File No: 2019/339289

Our Ref: R/2014/13/D

Art Gallery NSW Expansion Project – Sydney Modern – Modification 1 (SSD-6471-Mod-1)

I refer to your invitation to comment on the above mentioned State Significant Section 4.55 application to modify the consent for the Art Gallery NSW Expansion Project (“Sydney Modern”). The modification proposes replacing the approved seawater heat rejection system with a series of cooling towers located within the approved excavation footprint and changes to adjacent landscaping to accommodate the exhaust grill.

3 Building Section - Zone B - East-West 1 DA
Scale: 1 : 100

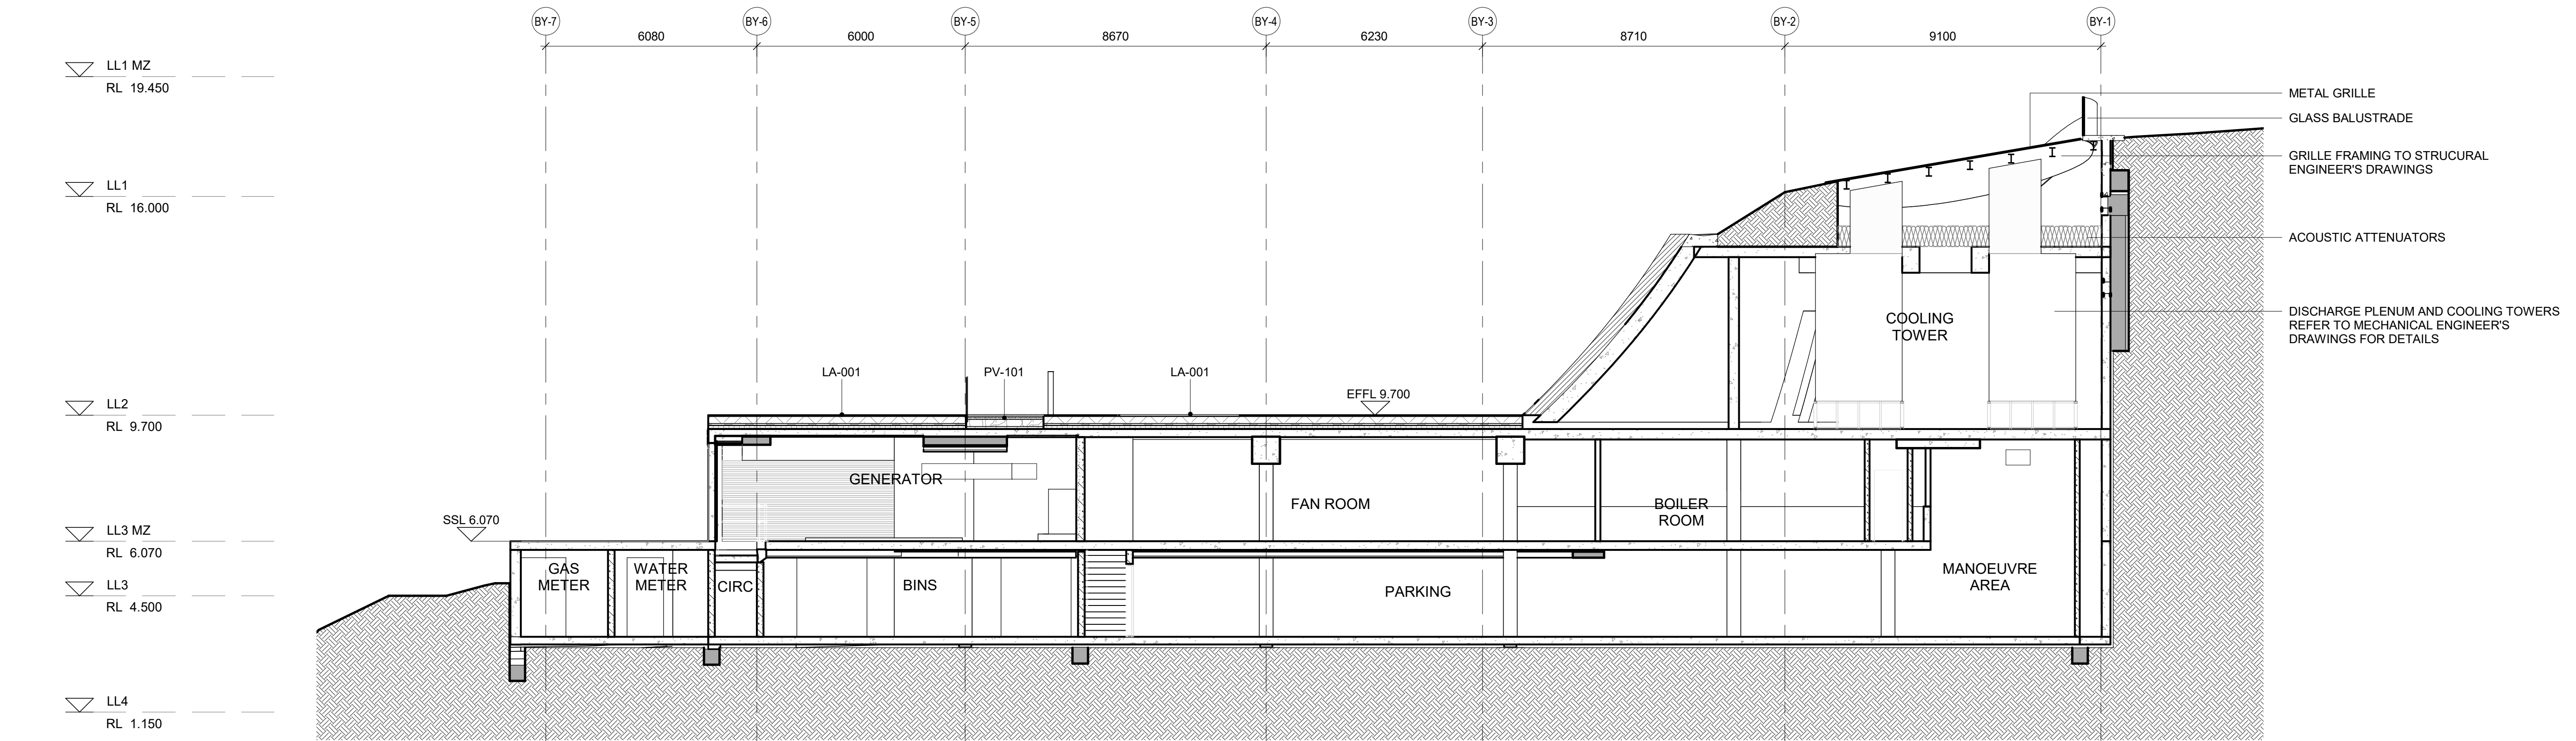
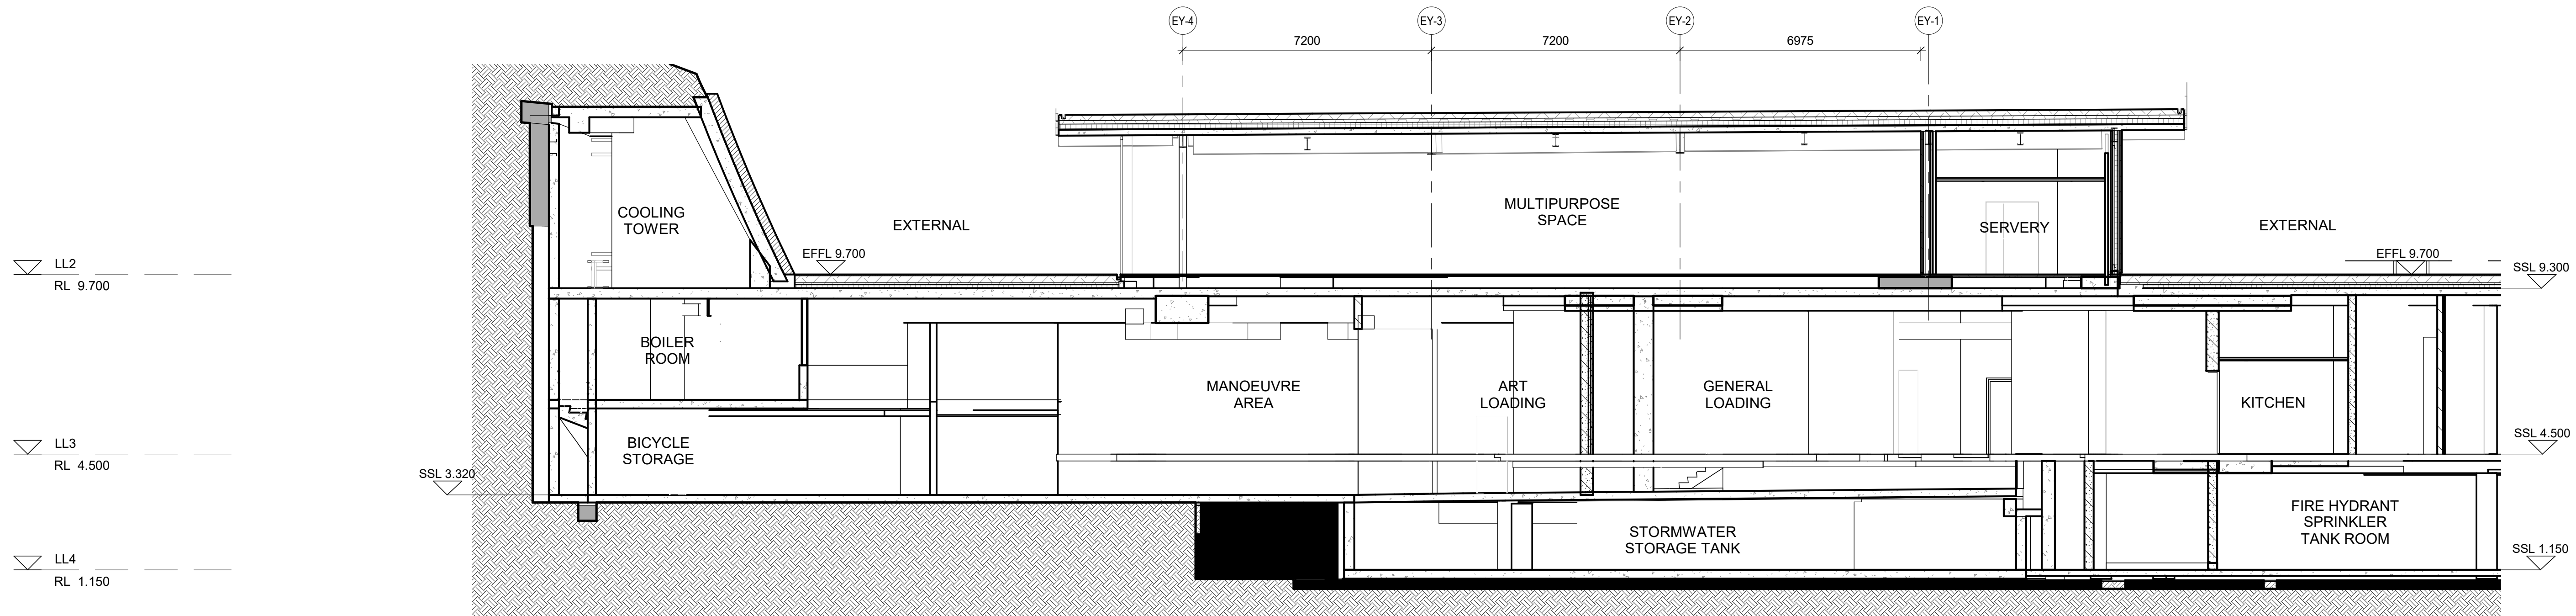
- Sections and elevations, including the finished height/RL of the grill
- Whether the grill will be screened for visual amenity, safety and security
- How the grill will interface with the adjacent fire egress path

1 Section A  
Scale: 1:100

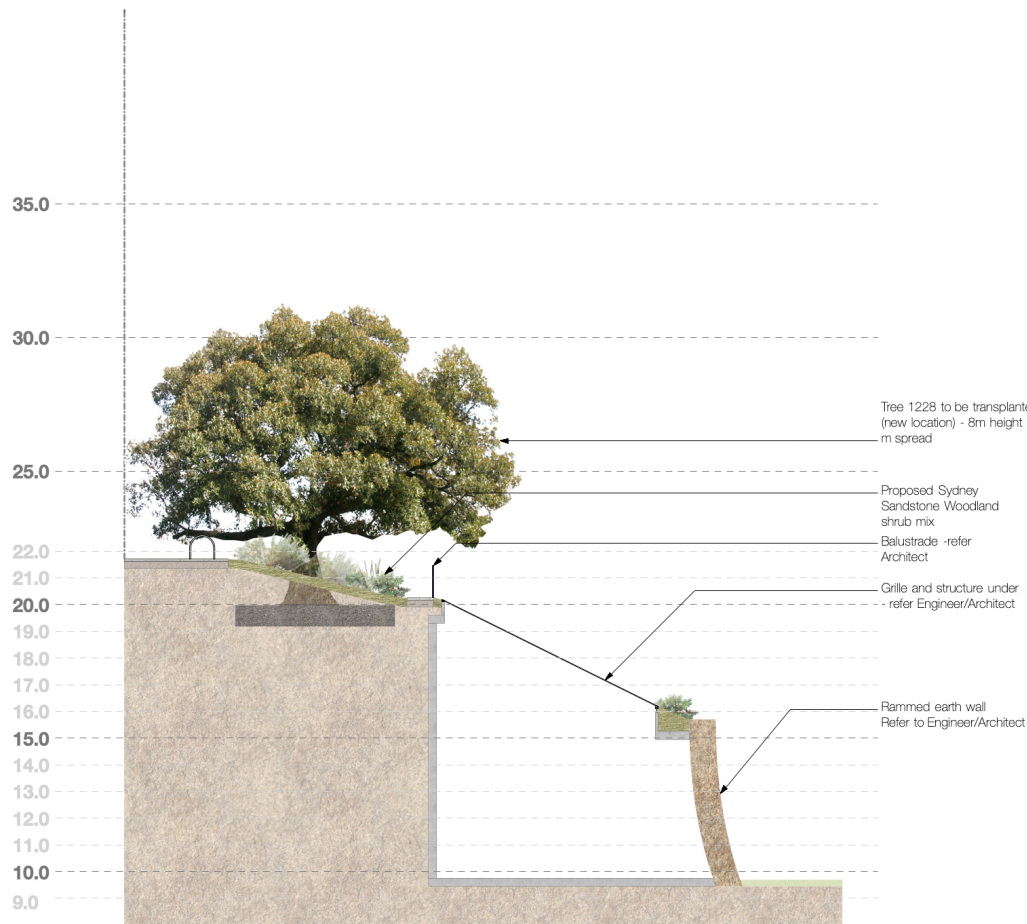
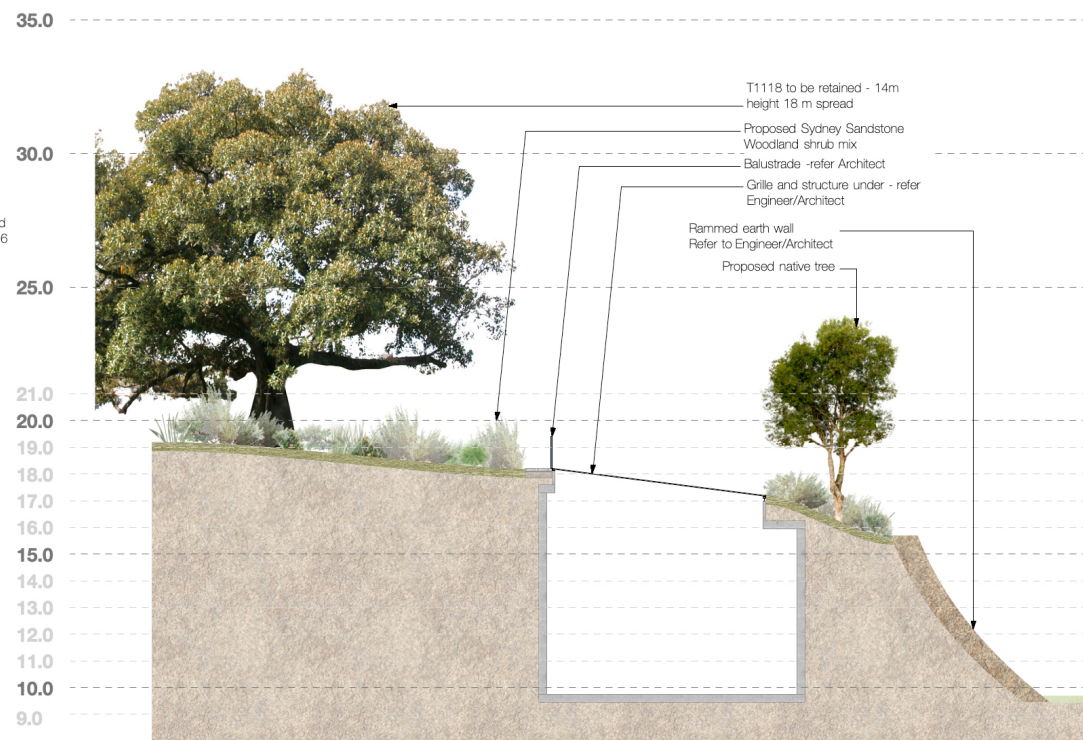
The application does not assess the impact of the heat exhaust and grill on the tree canopies and root protection zones of trees T1118 (existing) and T1228 (new) or the impact on surrounding vegetation and the public domain. Accordingly, concern is raised that the modification will have an adverse impact on the success of the surrounding landscaping and visual amenity from, and comfort of, the public domain.

- The new 8m diameter grate will be a large new element within the landscaped area alongside Mrs Macquarie's Road. It is not clear from the photomontages whether the new grate will be visible from the road. The plans provide no details (materials, colour, height above ground, elevations or sections) to allow accurate assessment of the visual impact of the new grate.
